**DEVELOPMENT REVIEW BOARD  
AGENDA**

**Project #1008519 - Tract(s) A-1-C-1-A, Cryer**

Re: Landscape Design

**City of Albuquerque  
Planning Department  
Inter-Office Memorandum**

L1.02

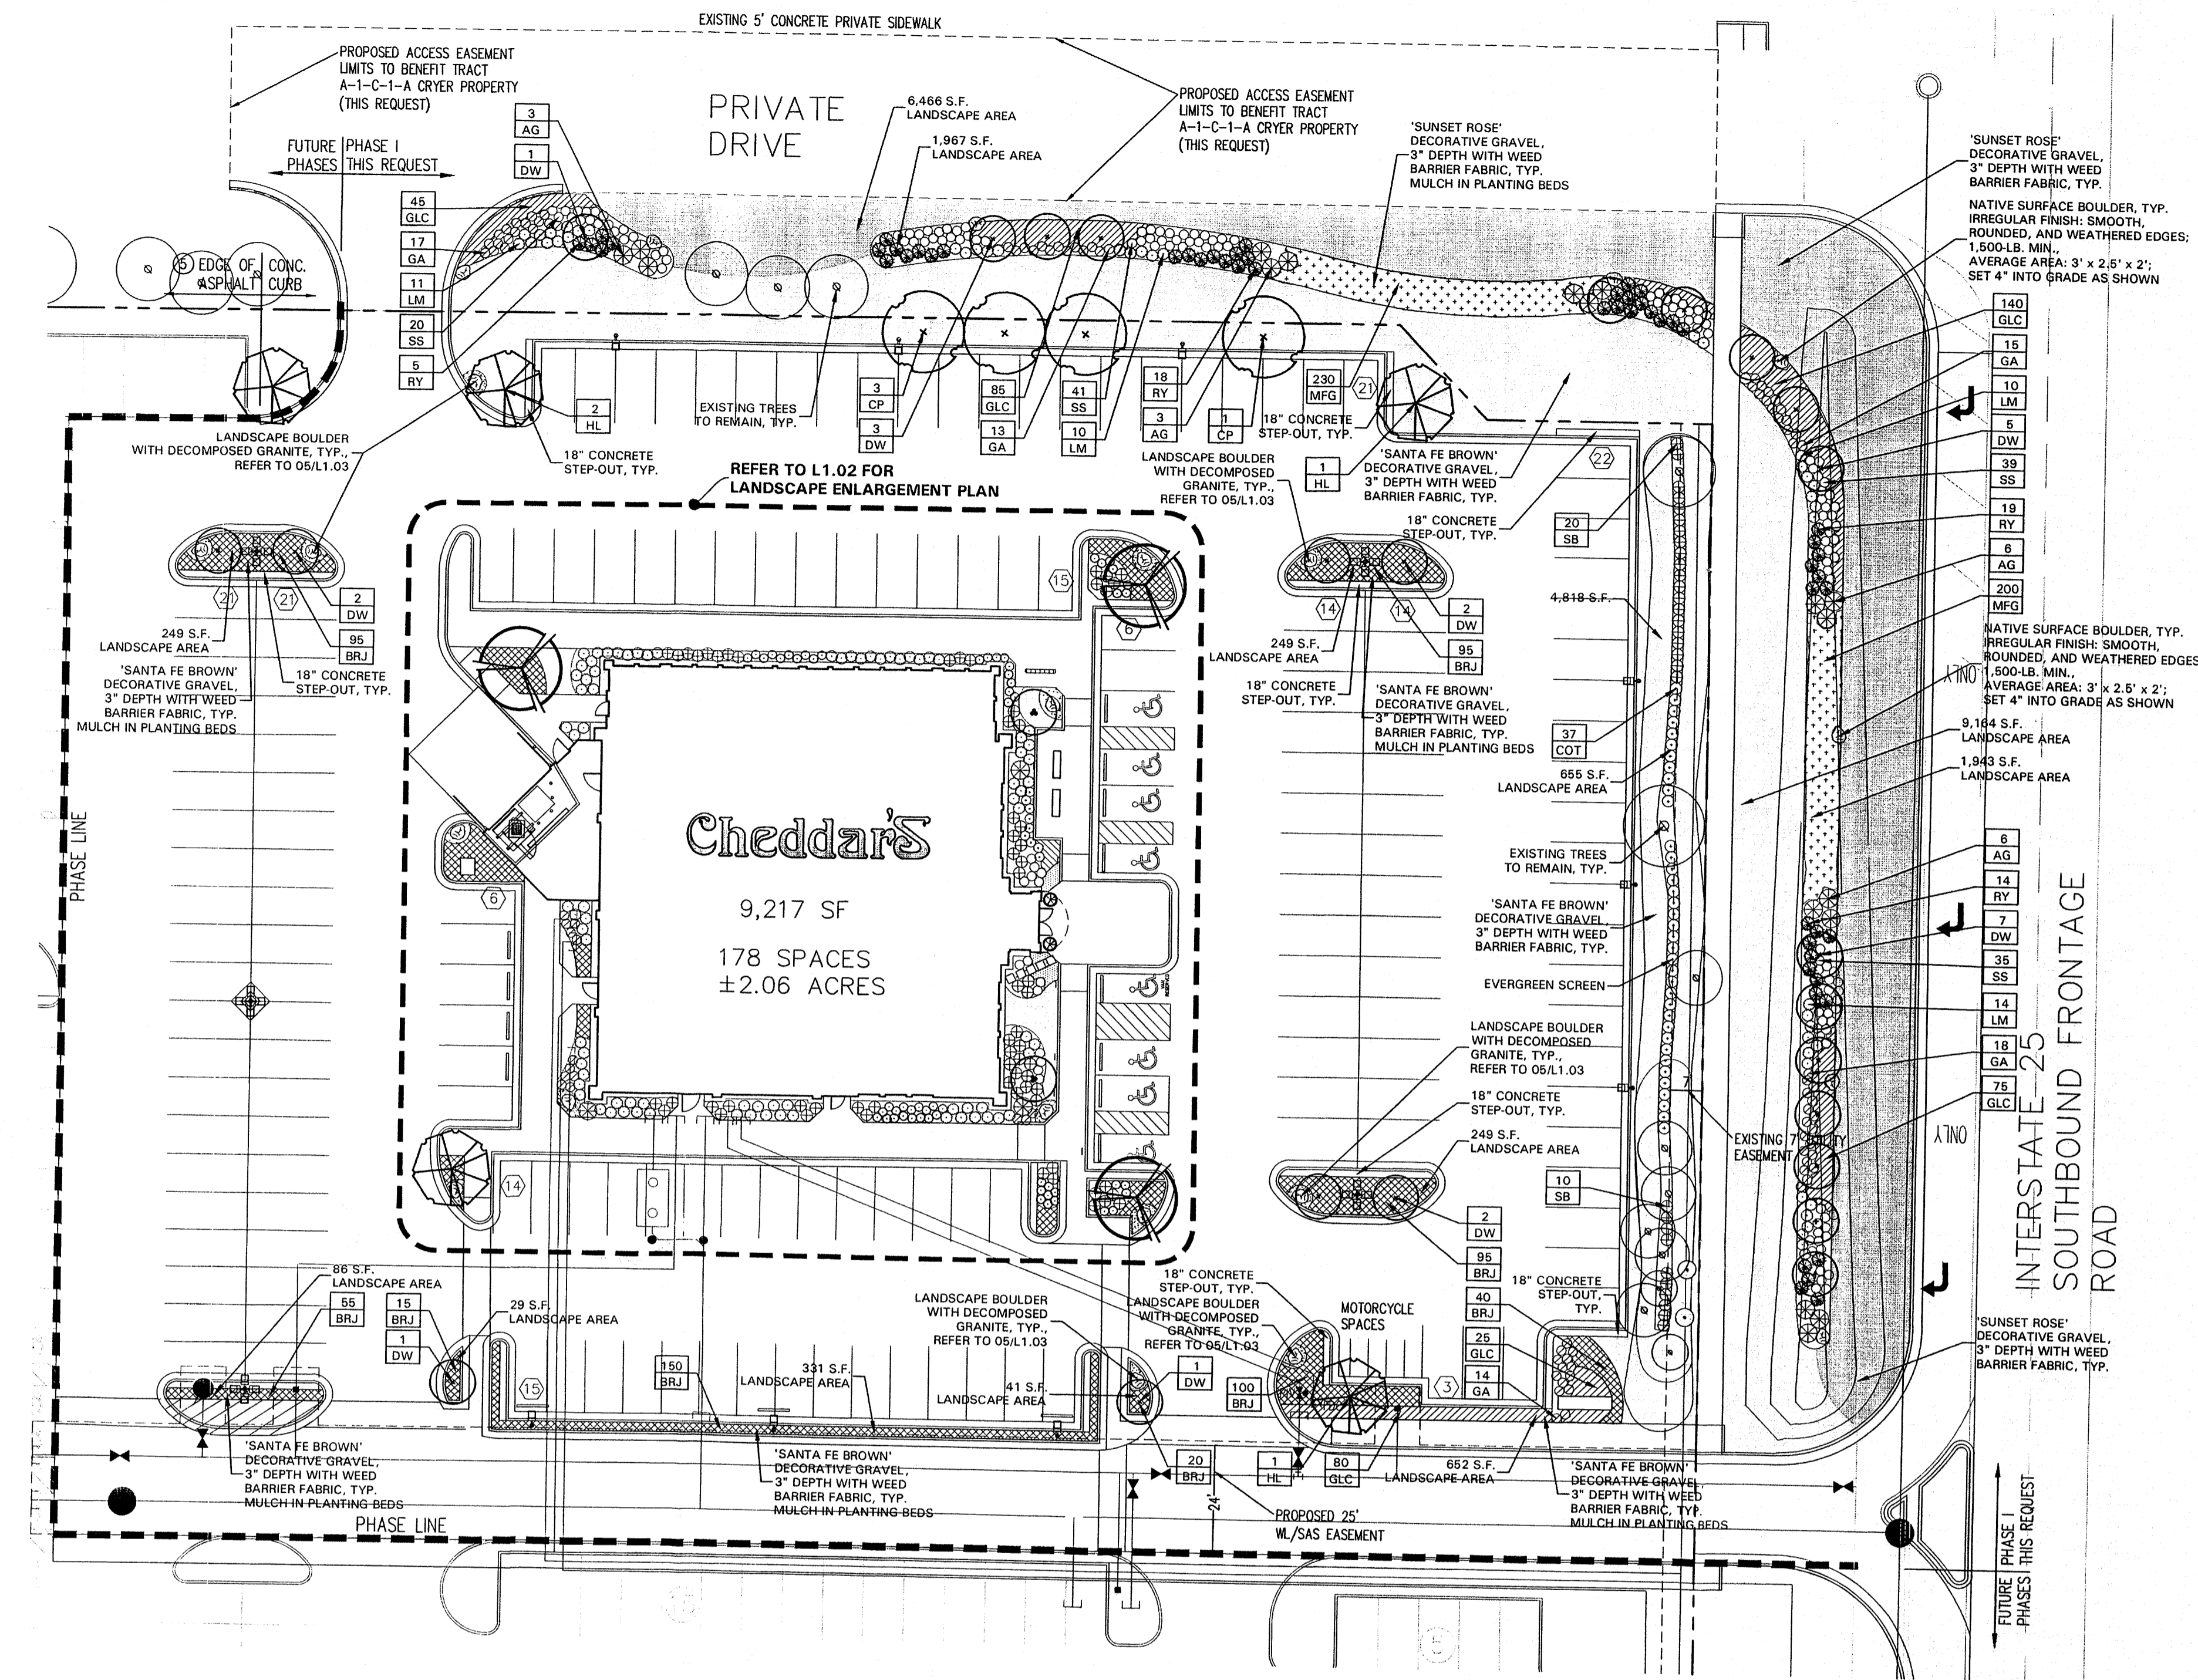
1. Existing established trees should be retained and incorporated into the landscape plan as requested by conditions of EPC approval.
2. Remarks indicating height and spread of trees are incorrect unless these remarks are meant to identify the minimum size at time of planting. These are mostly very large trees and will be wide spreading at maturity. Please refer to the Albuquerque Water Authority Plant List provided for your reference.

3. Trees should be planted in swales rather than on top of berm. Berm is not necessary for screening parking so existing trees can be retained and area can be redesigned to provide a swale to hold rainwater on site for additional deep watering to trees.

4. *Acer grandidentatum* is not a good candidate for this location as it prefers more water and less heat than will be provided on this site. *Acer saccharum* v. *grandidentatum* is a somewhat better choice however, it is unlikely to thrive in this harsh location. River rock mulch, although a good choice for most situations in Albuquerque would add to distress to this variety of tree in this location. The Shademaster Honey Locust is a better choice for height and shade and will thrive assuming that adequate irrigation is provided.

5. Please re-review plant selections.. for example, *nerium oleander* and *Philadelphus* spp are not hardy here.
